Conservation Area Advisory Committee

Meeting Date : 14 Mar 2012

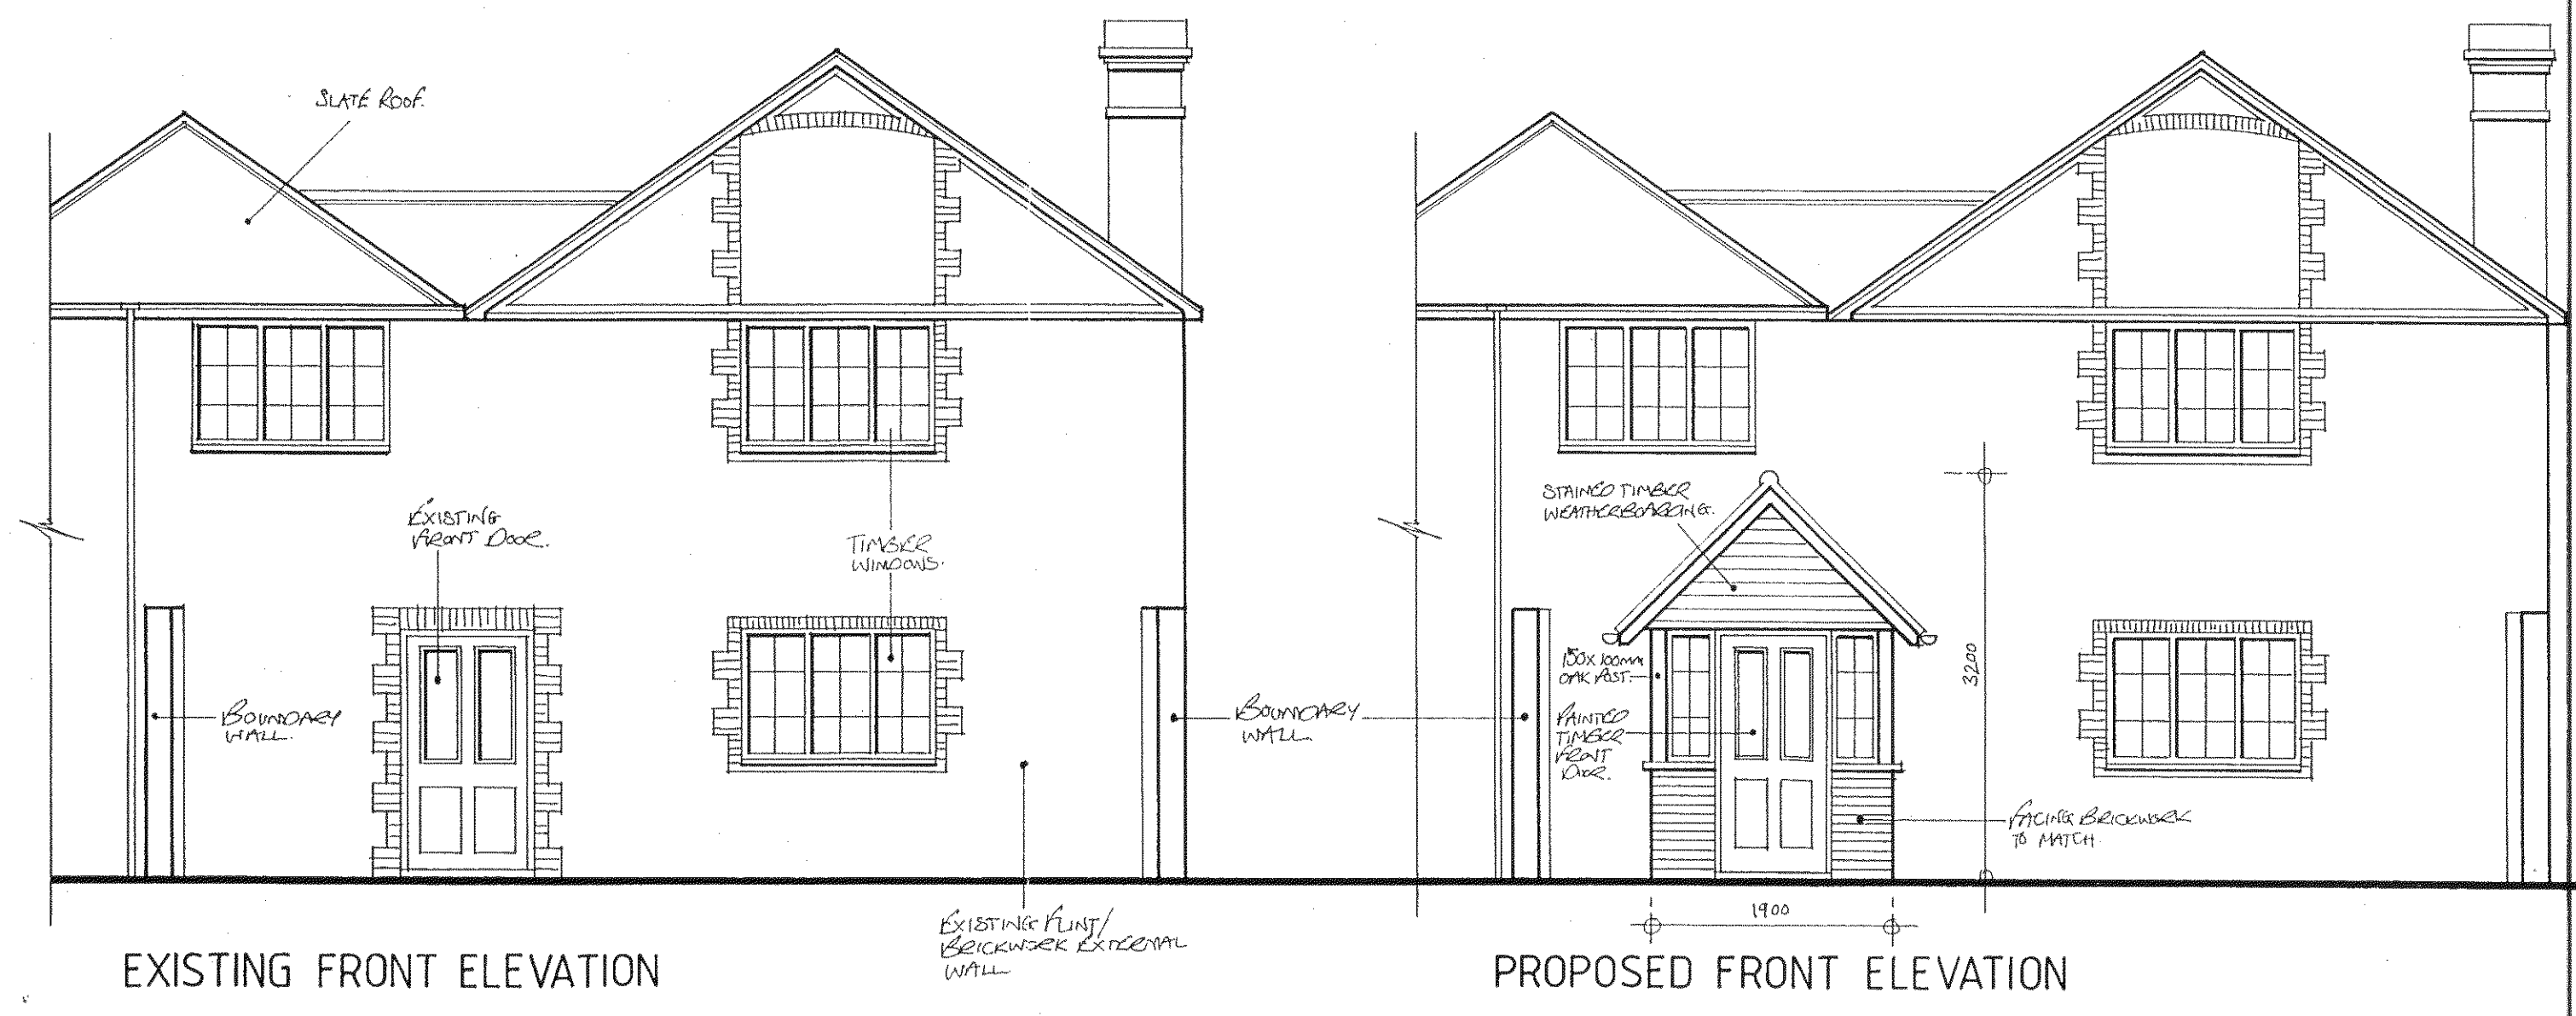
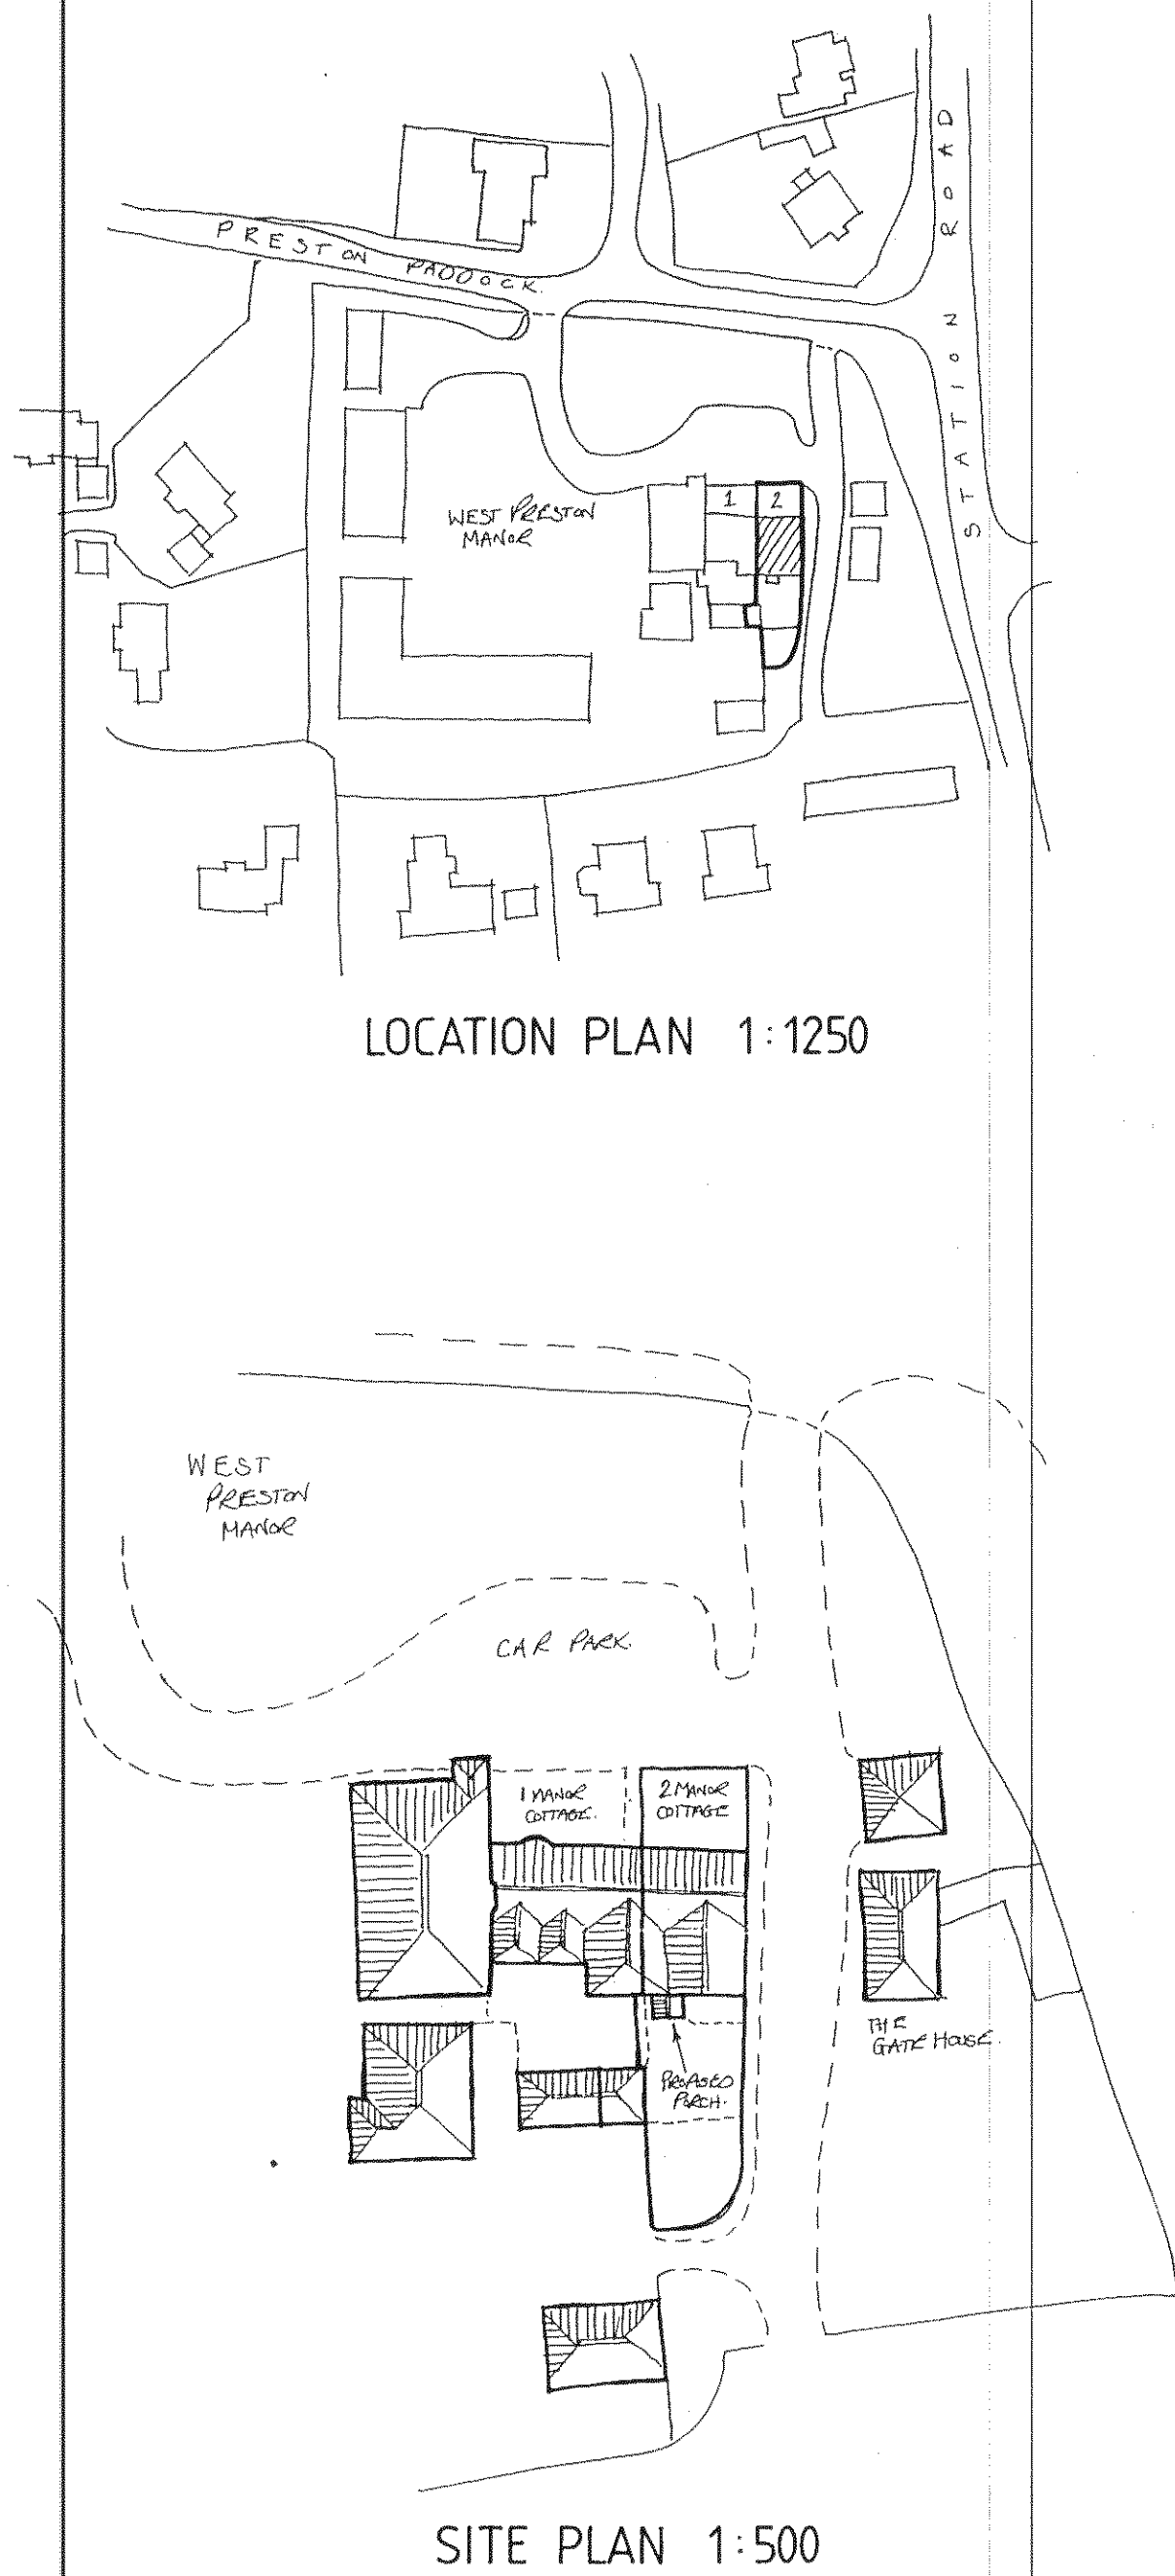
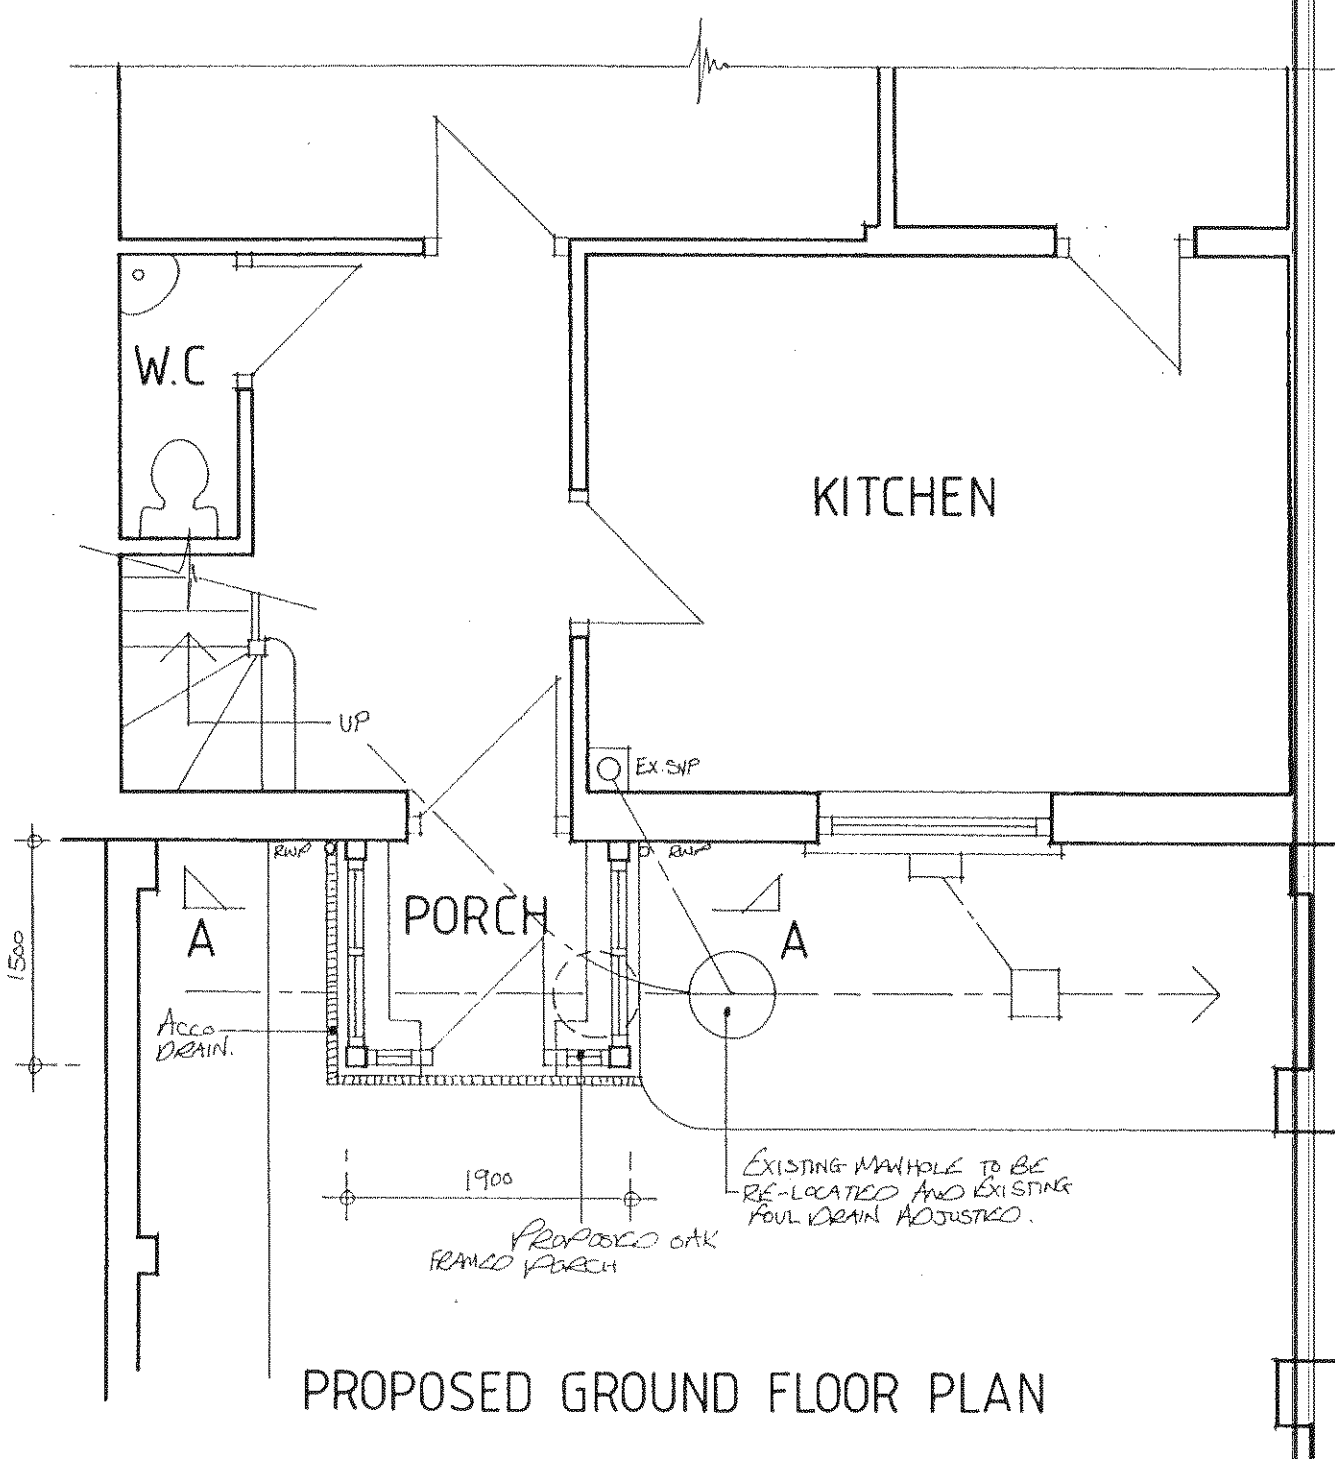
App No	Description/Address	Comment	Recommendation/Observation
<u>R/72/12/</u> 1	Proposed front porch. Manor Cottage 2 West Preston Manor Station Road Rustington BN16 2AF	No objection	High quality materials and details should be used
<u>R/73/12/L</u>	Application for Listed Building Consent for proposed front porch Manor Cottage 2 West Preston Manor Rustington BN16 2AF	No objection	
<u>R/92/12/TC</u>	Reduce 2no. Sycamore trees by 50% within the Rustington Conservation Area Elm Farm 34 The Street Rustington BN16 3PA	No objection
